10th February 2021

RE: OBJECTION TO ERECTION OF EXTENSIONS AND ALTERATIONS TO EXISTING COACH HOUSE TO FORM ANNEXE ACCOMMODATION ASSOCIATED WITH COACHWAYS, 1A DINGLEY ROAD, EDGERTON, HUDDERSFIELD, HD3 3AY AND PARTIAL DEMOLITION OF EXISTING BUNGALOW WITH RE-BUILD TO FORM 2 STOREY DWELLING (WITHIN A CONSERVATION AREA)

LPA REF: 2021/90126

Proposed Plans & Elevations

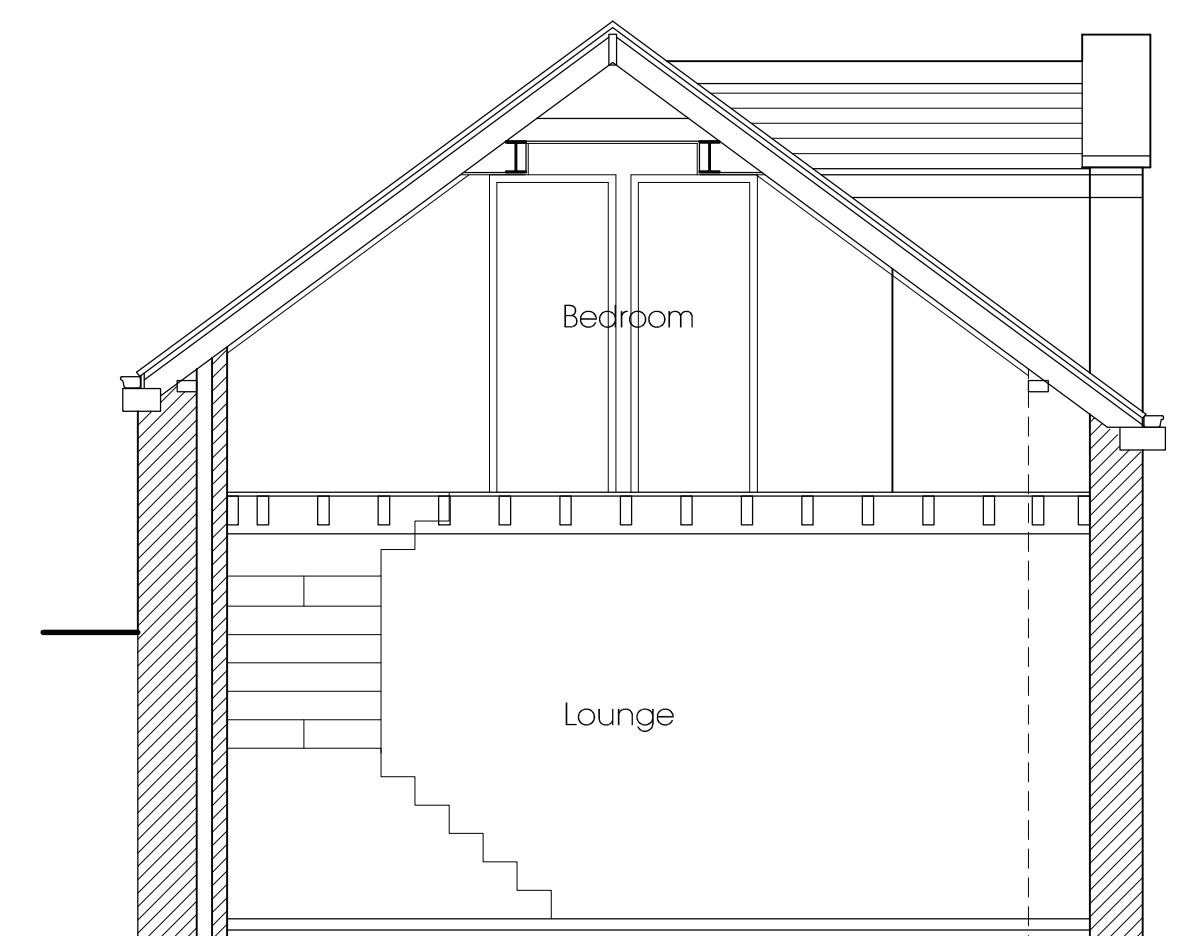
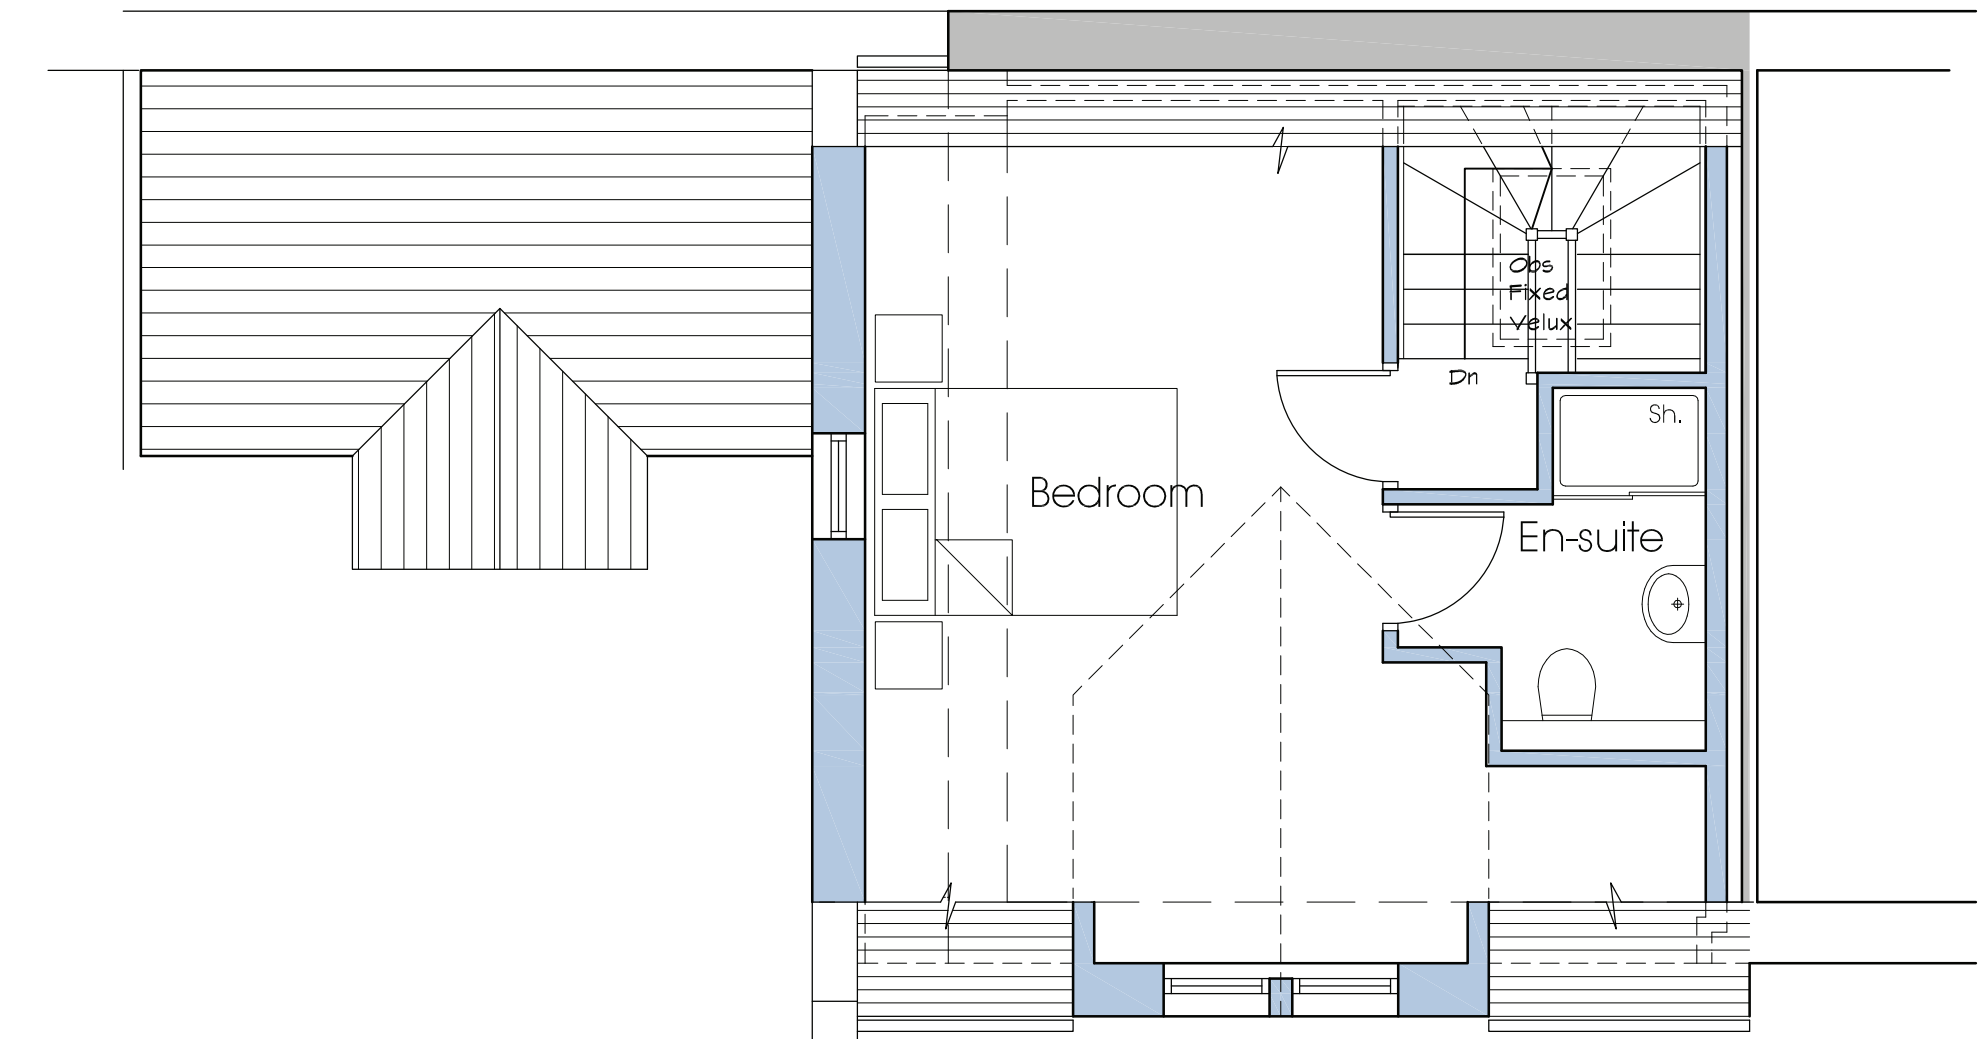
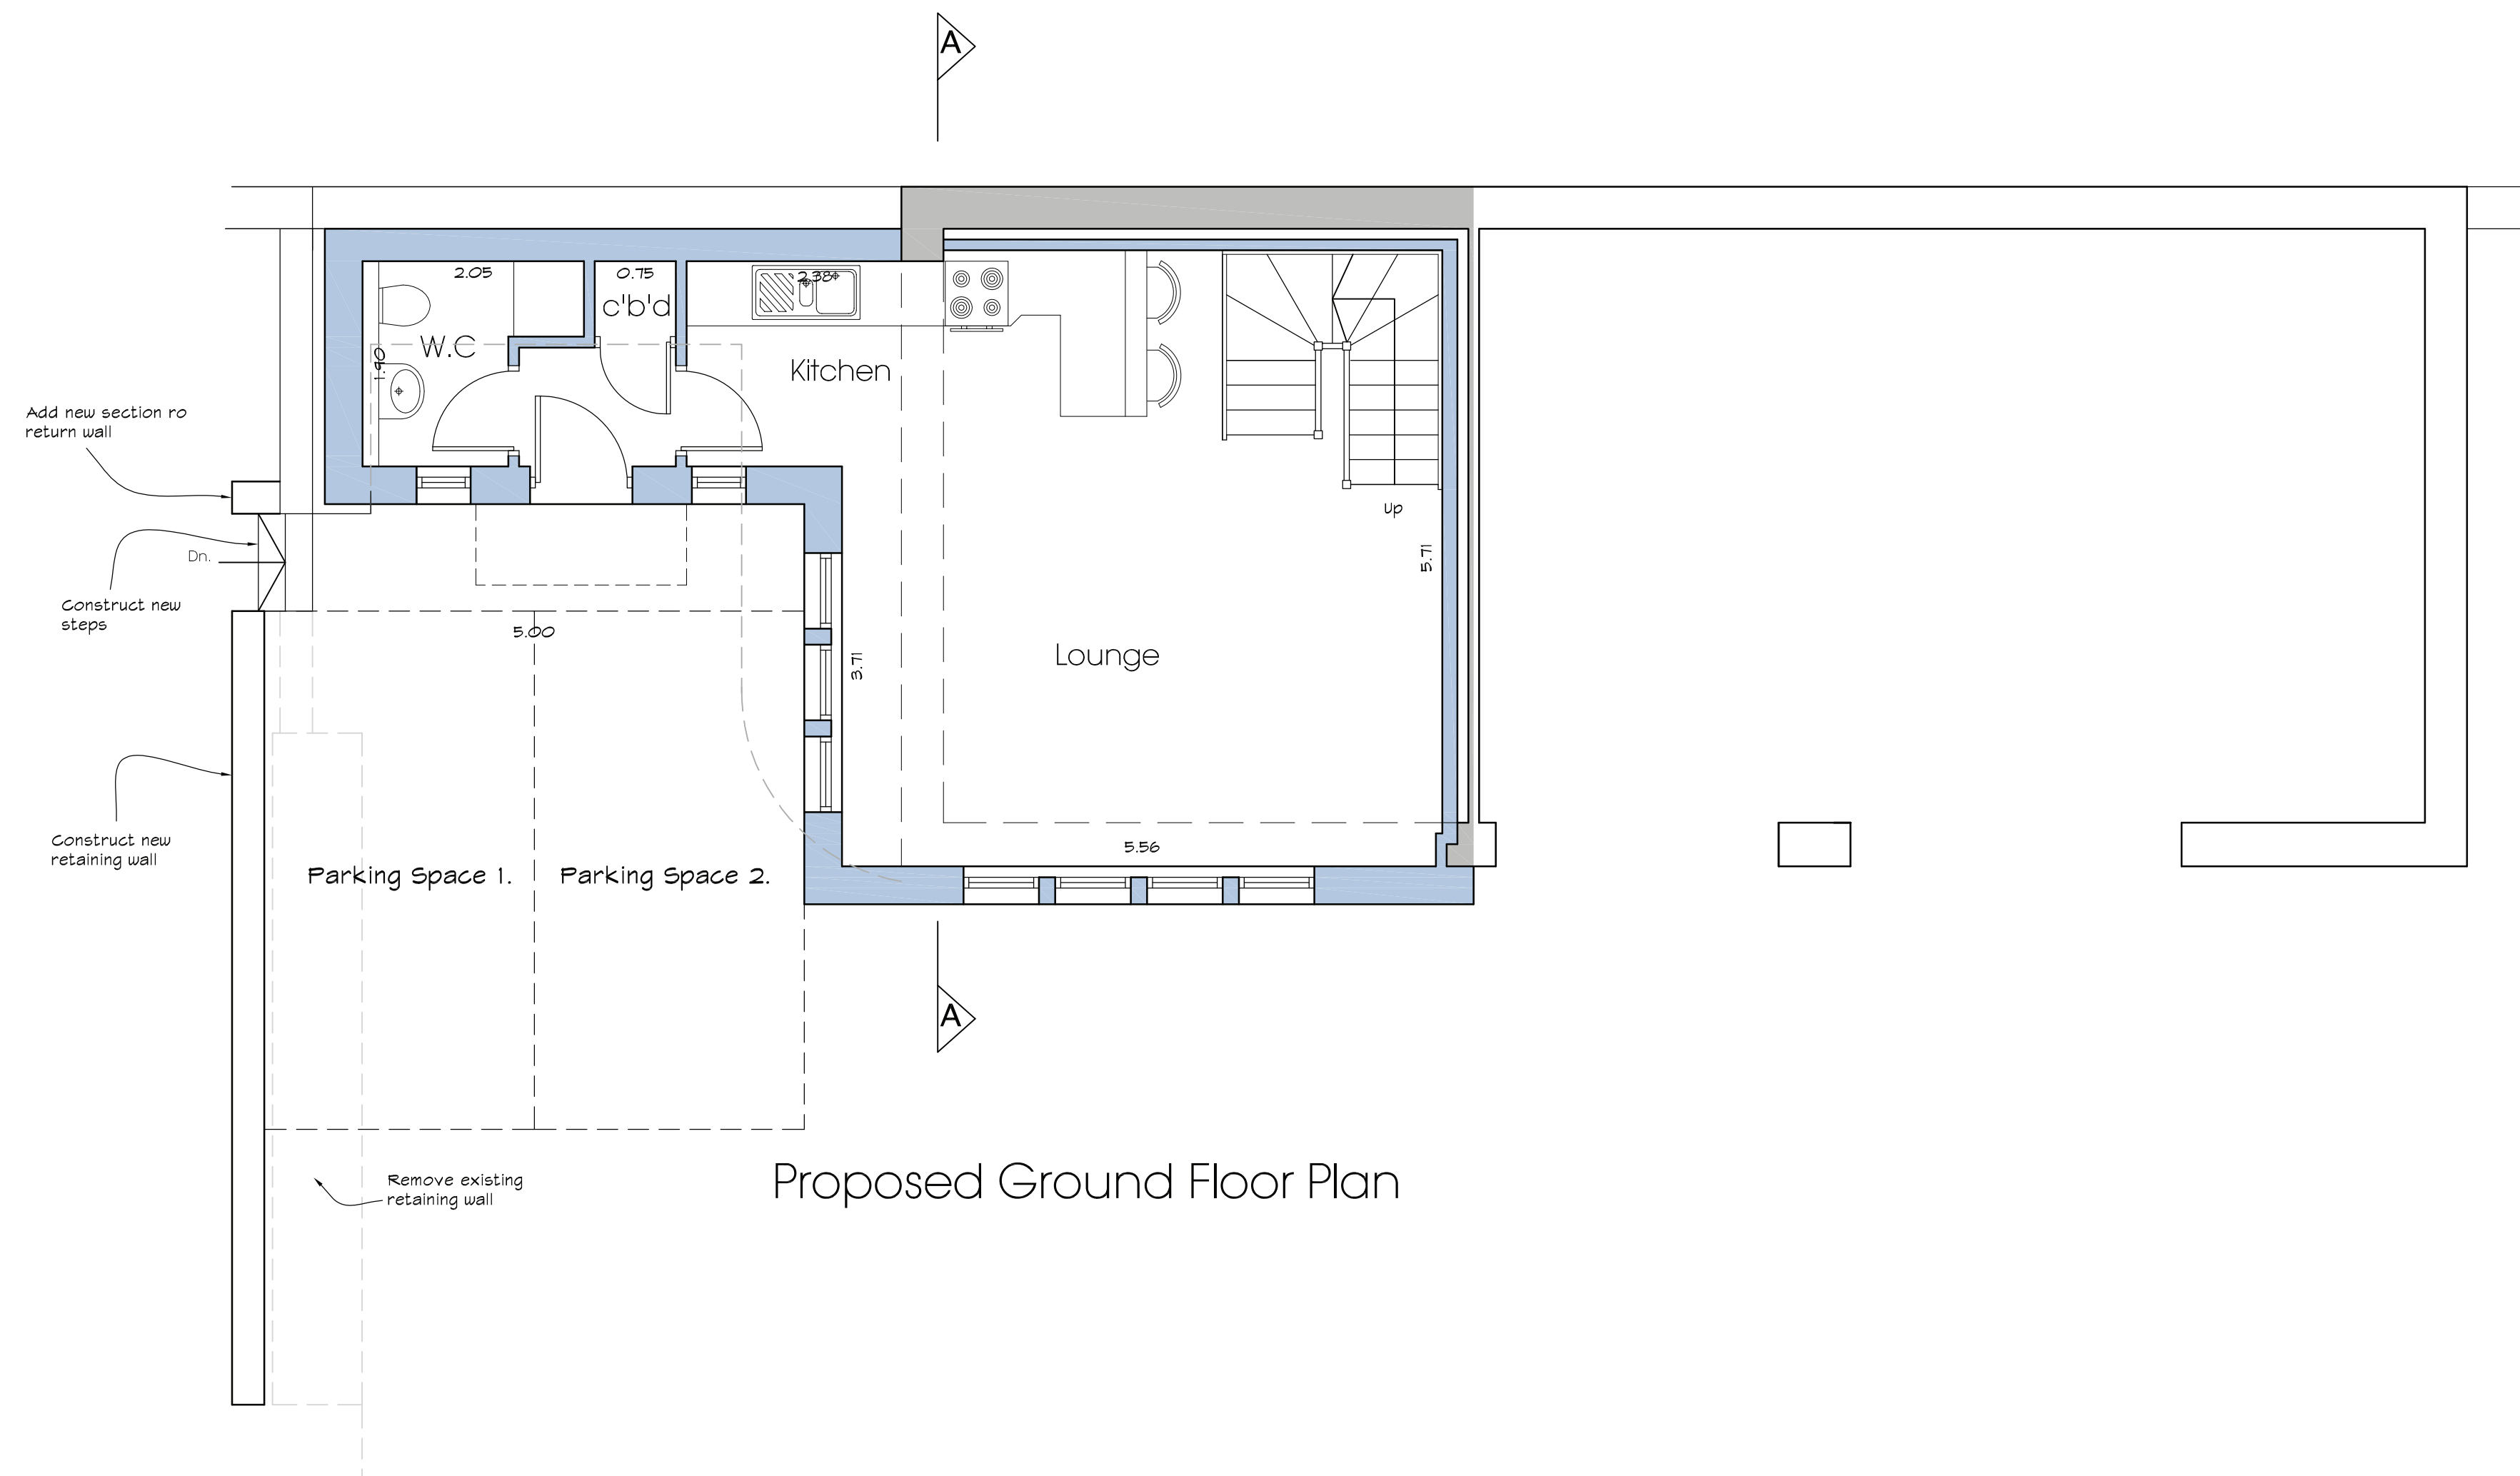
The applicant has applied for the conversion and extension of their part of the coach house to form an annexe to the main dwellinghouse. The plans show that the annexe would comprise of an open plan lounge and kitchen area, a W.C. and a small entrance hall area on the ground floor with one bedroom and en-suite bathroom on the first floor. Two designated car parking spaces have also been proposed in front of the annexe.

Given the type and amount of accommodation proposed, our clients are concerned that the annexe would not be ancillary residential accommodation for the enjoyment of the main house but would

instead be used as separate primary living accommodation. The proposed annexe would be fully self-contained providing all of the facilities necessary for independent day-to-day living e.g. kitchen, lounge, bedroom, bathroom, plus its own allocated parking spaces. Access to the annexe would also be entirely separate from the access to the main house.

The front elevation of the coach house looks directly towards the side elevation of our clients' property. Habitable room windows are proposed in the front elevation on the proposed 'annexe, and our clients also have windows in their side elevation. The separation distance of just under 13m is therefore felt to be unacceptable as this would create additional overlooking and loss of privacy for our clients, and as such would be of detriment to their residential amenity.
